# East Anglia ONE North and East Anglia TWO Offshore Windfarms

## Applicants' Responses to Rule 17 Questions of 29 April 2021

Applicants: East Anglia ONE North Limited and East Anglia TWO Limited  
Document Reference: ExA.R17QC.D10.V1  
SPR Reference: EA1N\_EA2-DWF-ENV-REP-IBR-001058

Date: 6<sup>th</sup> May 2021  
Revision: Version 01  
Author: Royal HaskoningDHV

- East Anglia ONE North and East Anglia TWO Onshore Development Area
- Work No 19
- Survey Area
- Target Note

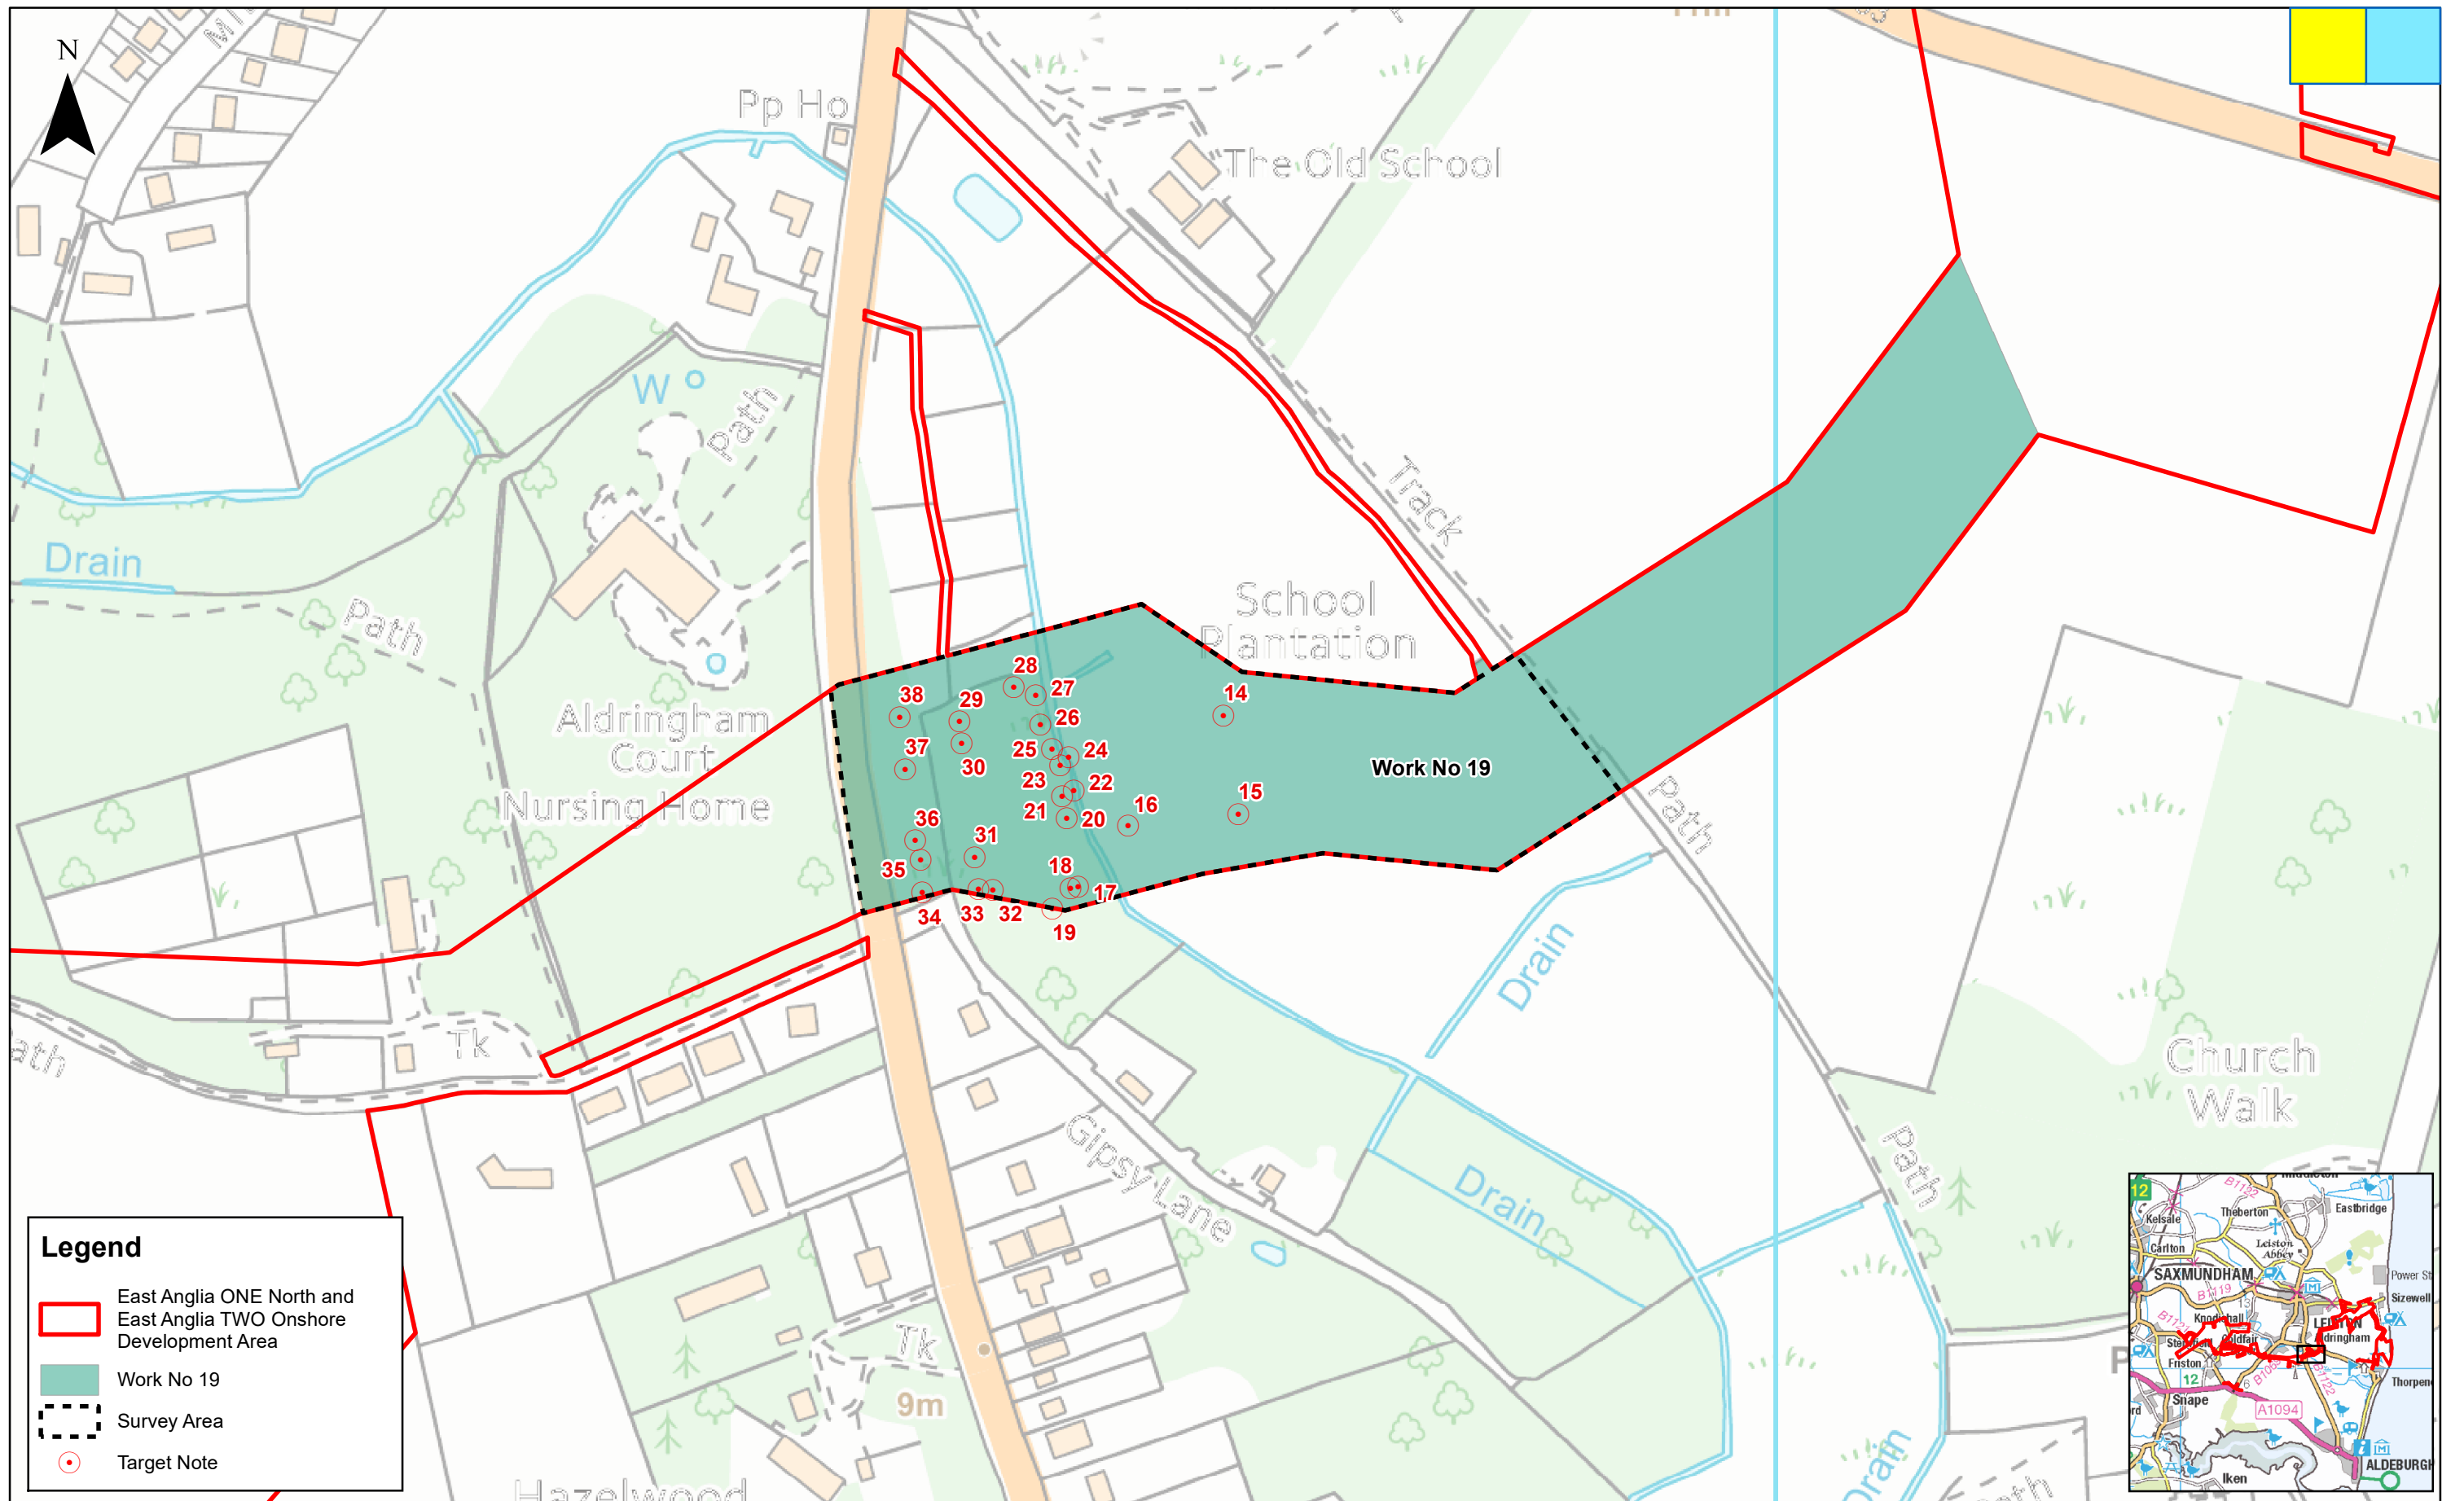
<b>Terrestrial Ecology</b>					
R17QC.2	The Applicants	1	2	<p><b>Ecology Survey Results</b> [REP6-035]</p> <p>Natural England's D7 response [REP7-073] indicated that surveys had not followed best practice in relation to</p>	<p>The Applicants have stated in various submissions to the Examinations that the February 2021 survey of the woodland at the Hundred River crossing had the primary aim of verifying the results of the survey</p>

R17QC	Question addressed to		Question	Applicants' Response	
			<p>timings and ground conditions, as many vegetation species are only evident in spring or summer and that the ability to identify these can be key to an adequate understanding of habitat type and its quality.</p> <ul style="list-style-type: none"> <li>• Will any further surveys be undertaken during spring and submitted into the Examinations?</li> <li>• If so, please indicate at which deadline additional survey results will be available.</li> <li>• If not, then please explain your reasoning, responding to comments from NE and other IPs on this matter.</li> </ul>	<p>already undertaken in April 2018 (April being within the optimal habitat surveying window). The February 2021 survey was only undertaken in response to information submitted by Suffolk Energy Action Solutions (SEAS) that was obtained from a site visit undertaken in January 2021 (REP5-108).</p> <p>The Applicants have additionally noted that across the ecological profession it is accepted that Phase 1 habitat surveys can be conducted all year round and would also note that in its cover letter at Deadline 9 (REP9-063) Natural England states that it <i>“is reviewing best available evidence and will provide further advice in relation to the potential ‘wet’ woodland and hairy dragonfly habitat at Deadline 10”</i>.</p> <p>However, in the interest of closing this matter to the satisfaction of the ExA, a third survey of the Hundred River crossing location will be undertaken during the month of May. A full survey report will be provided at Deadline 11.</p>
